Permit Number: 071288

has permission to Change of use w/ tenant fit-out from Multi-Family to 2 Family

AT 11 DEERING ST PORTLAND, OR 97201 046 B022001

Dept: Building **Status:** Approved with Conditions **Reviewer:** Chris Hanson **Approval Date:** 12/10/2007

SECOND & THIRD FLOOR FRAMING PLANS

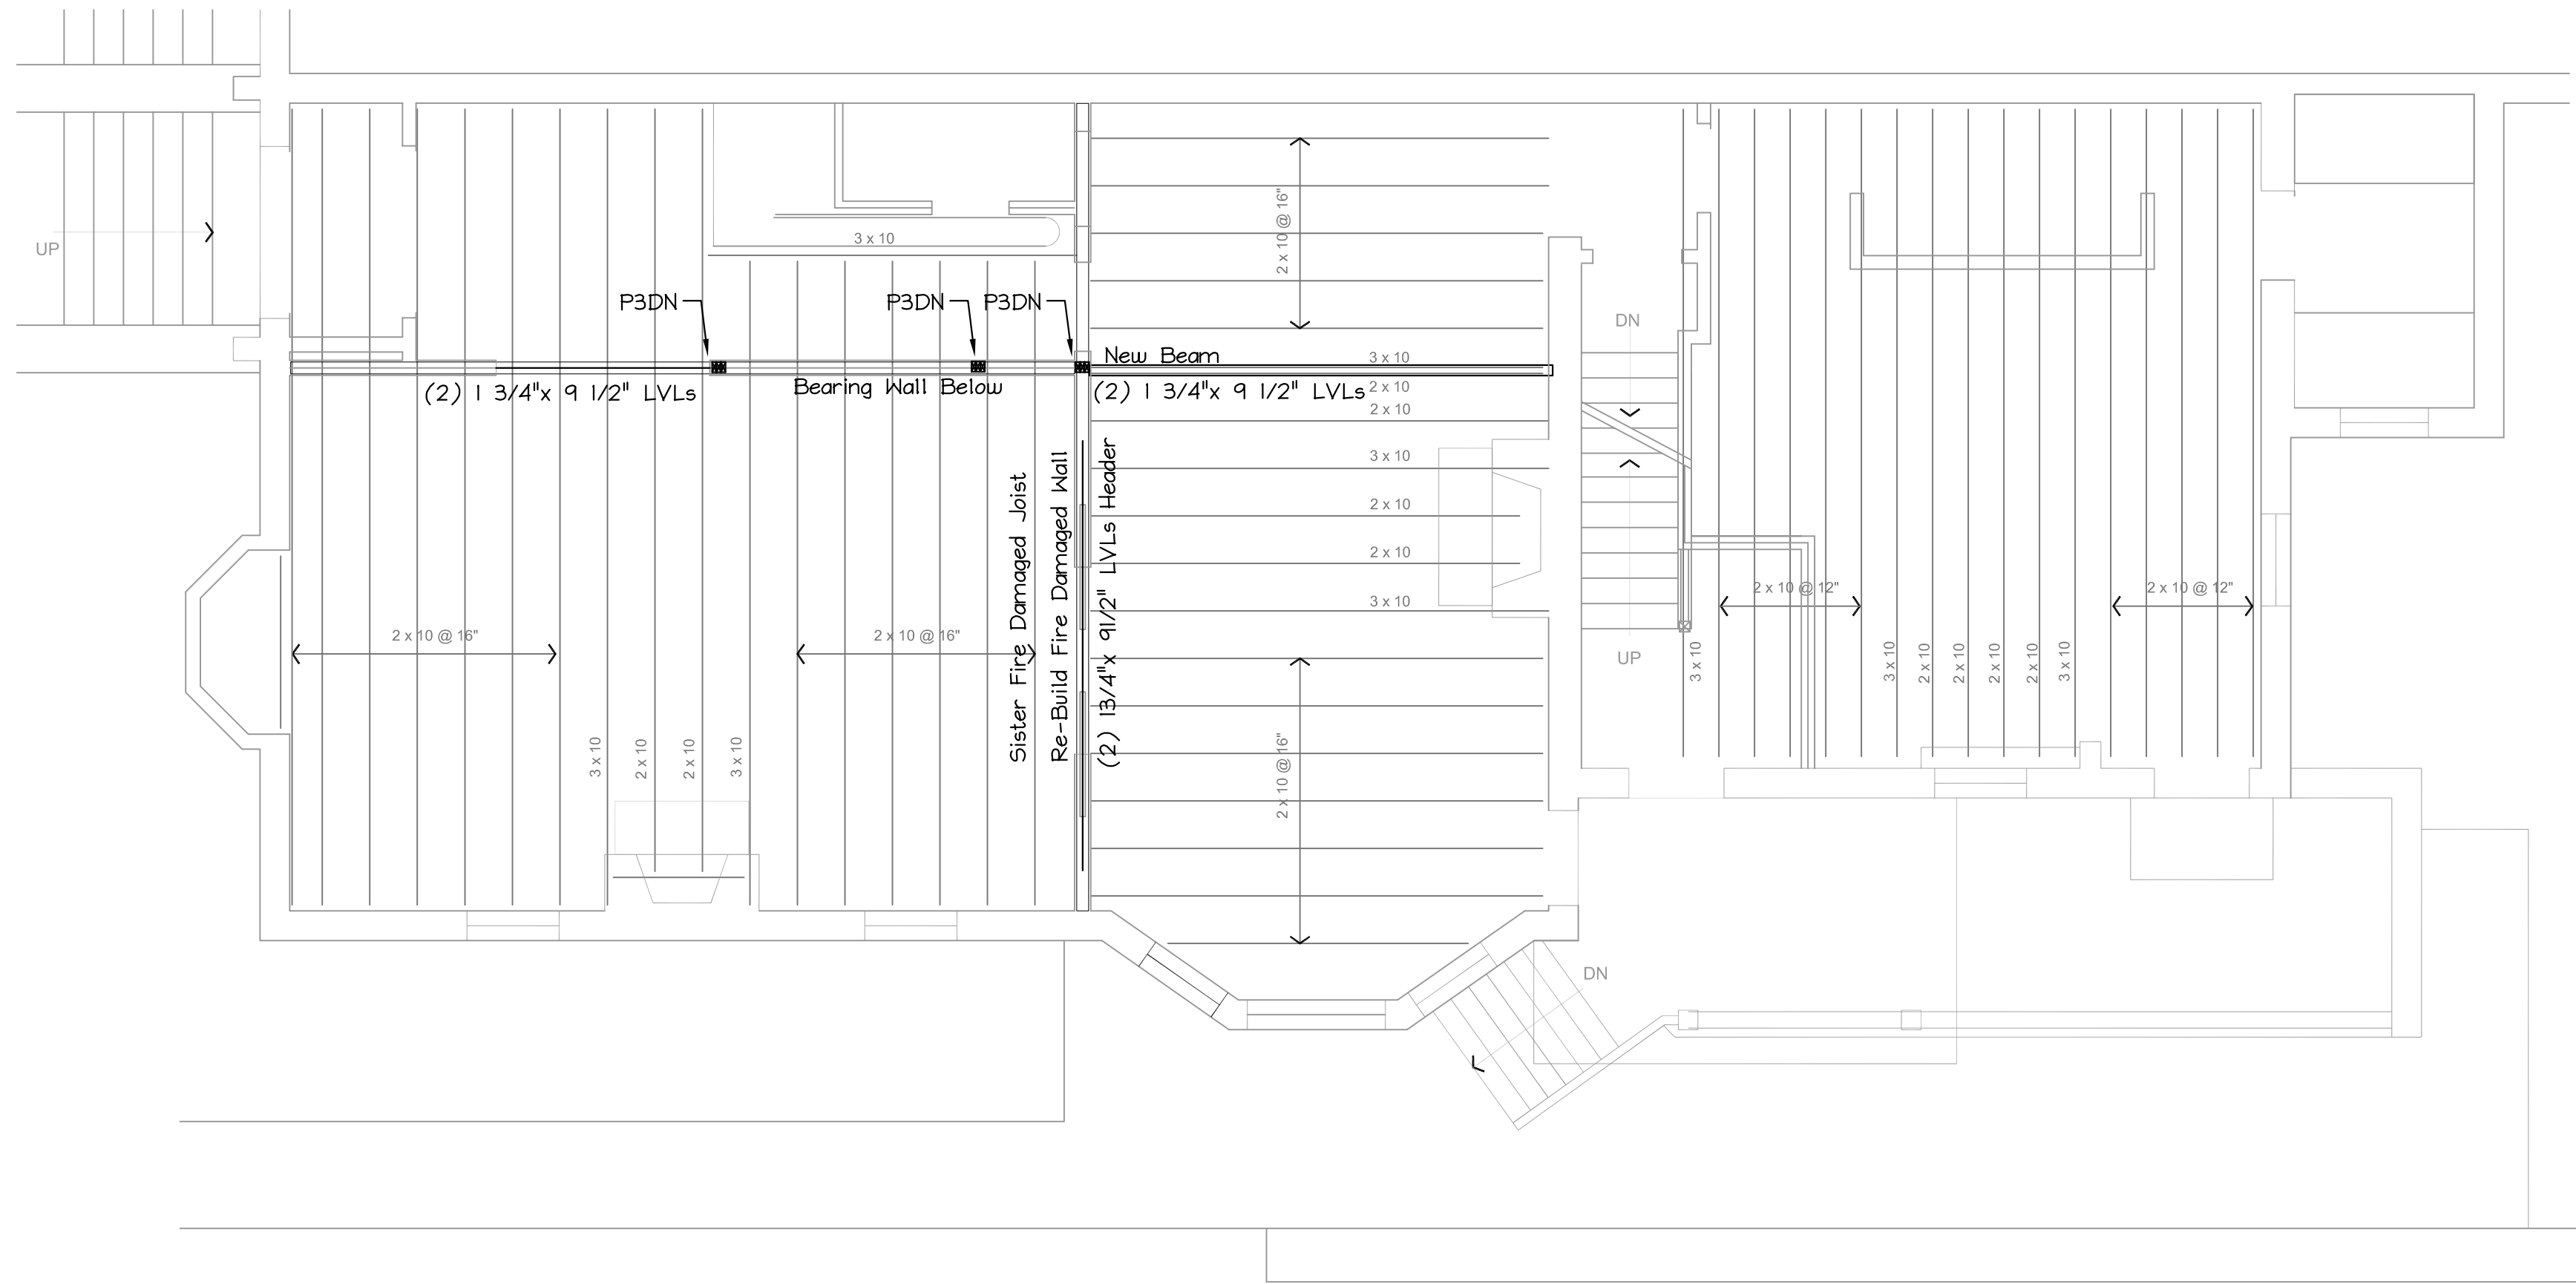
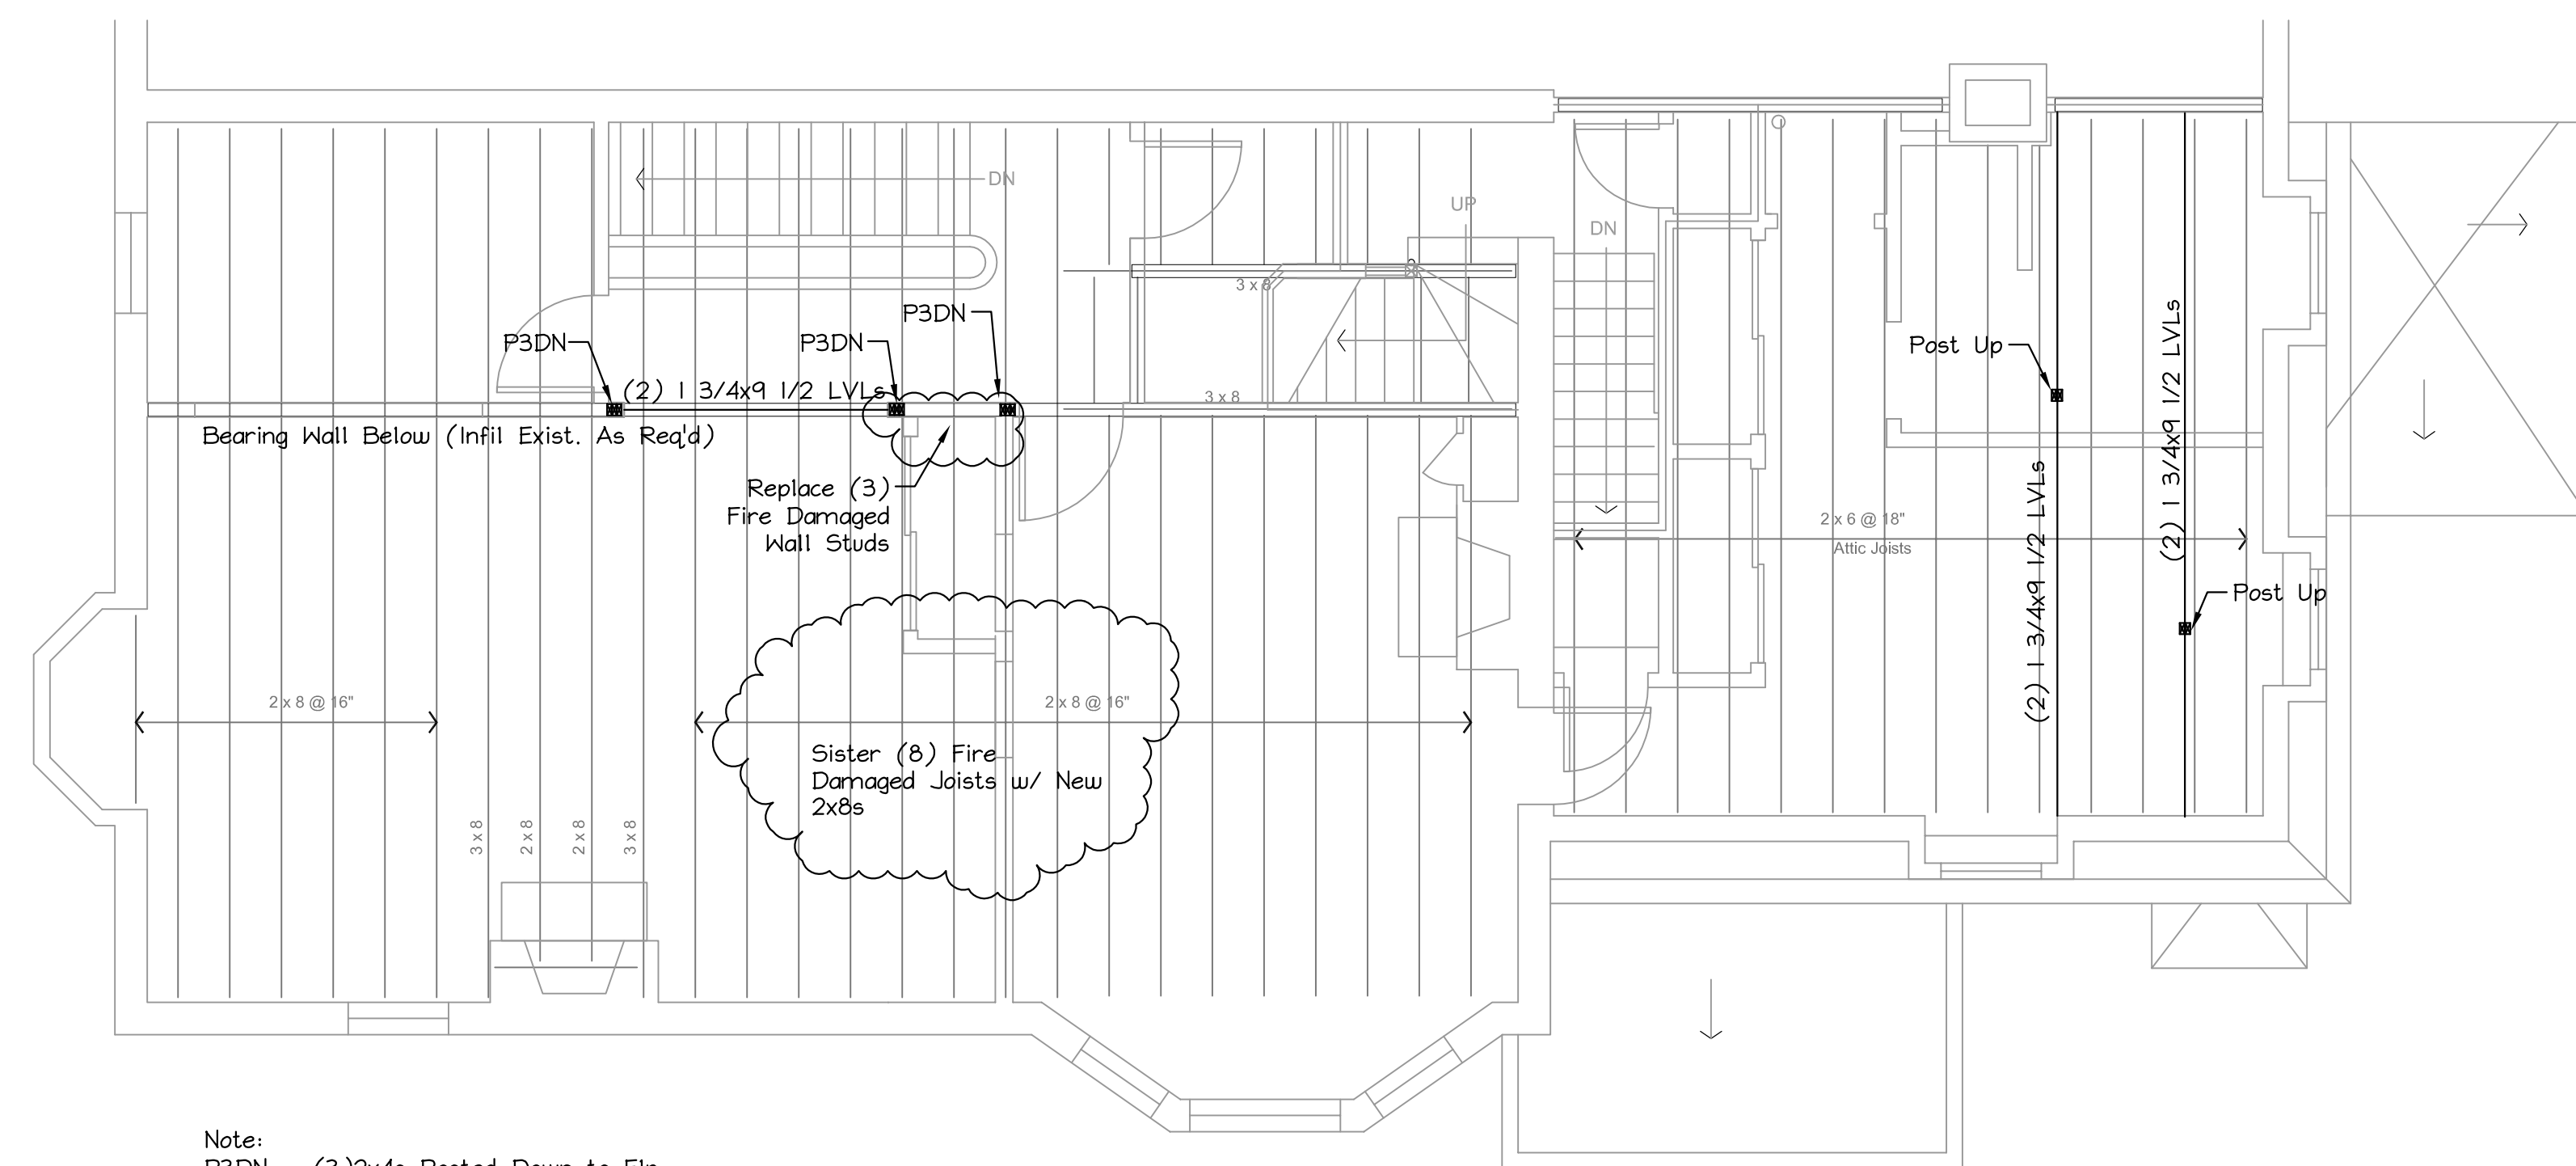
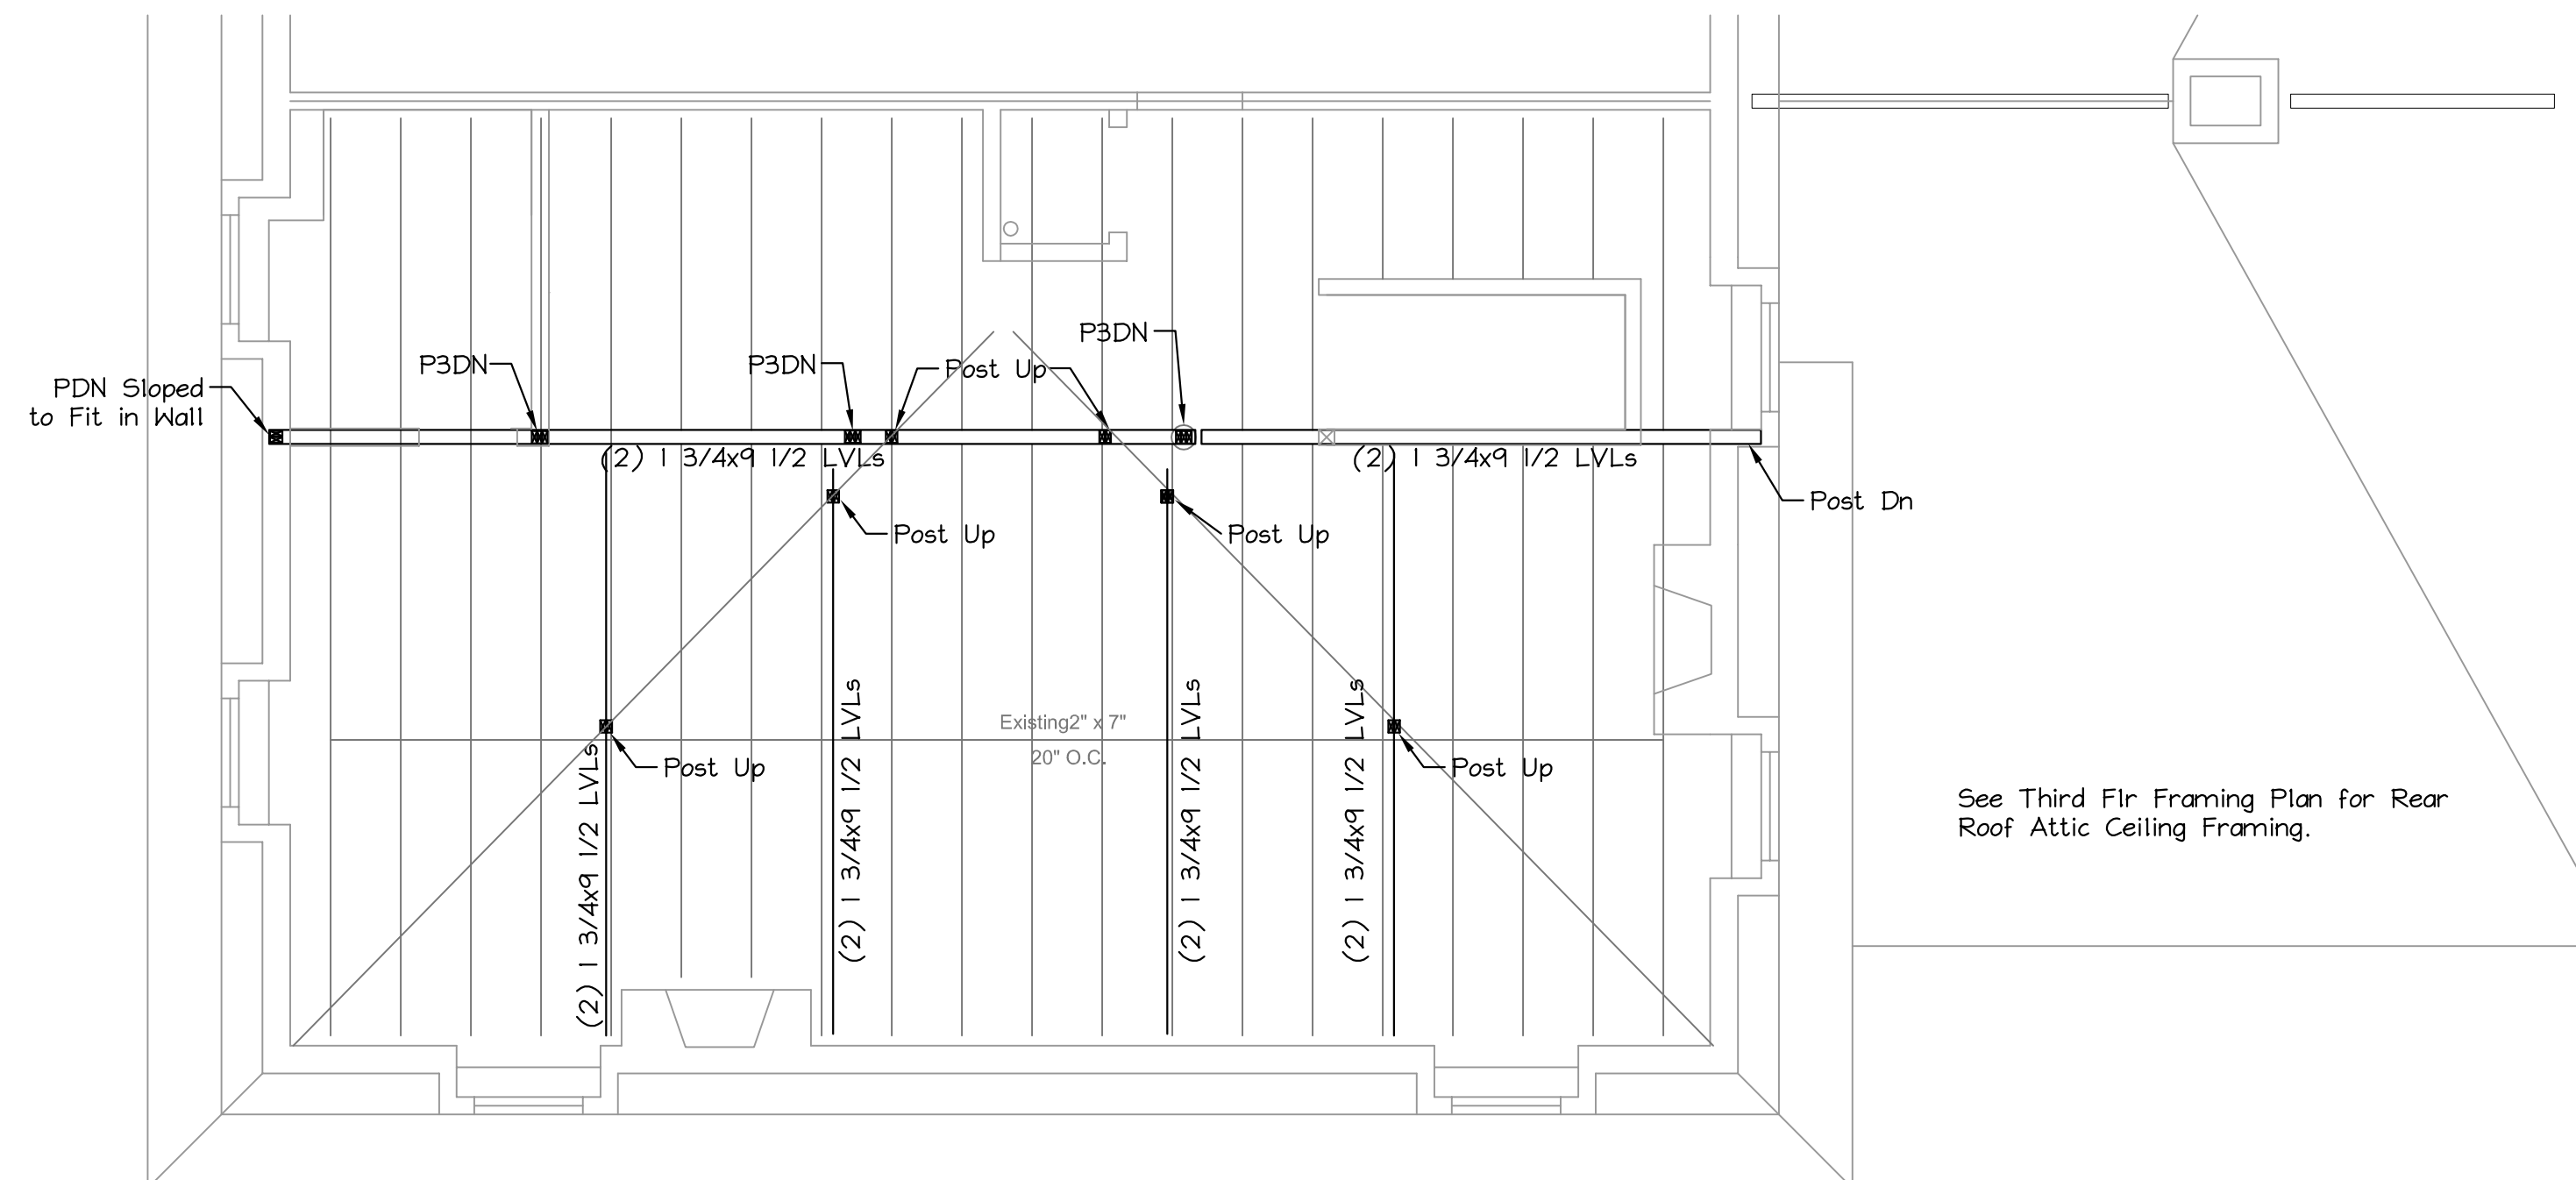
- 6) ANY exterior work requires separate review and approval thru Historic Preservation
- 7) The design load spec sheets for any engineered beam(s) must be submitted to this office.
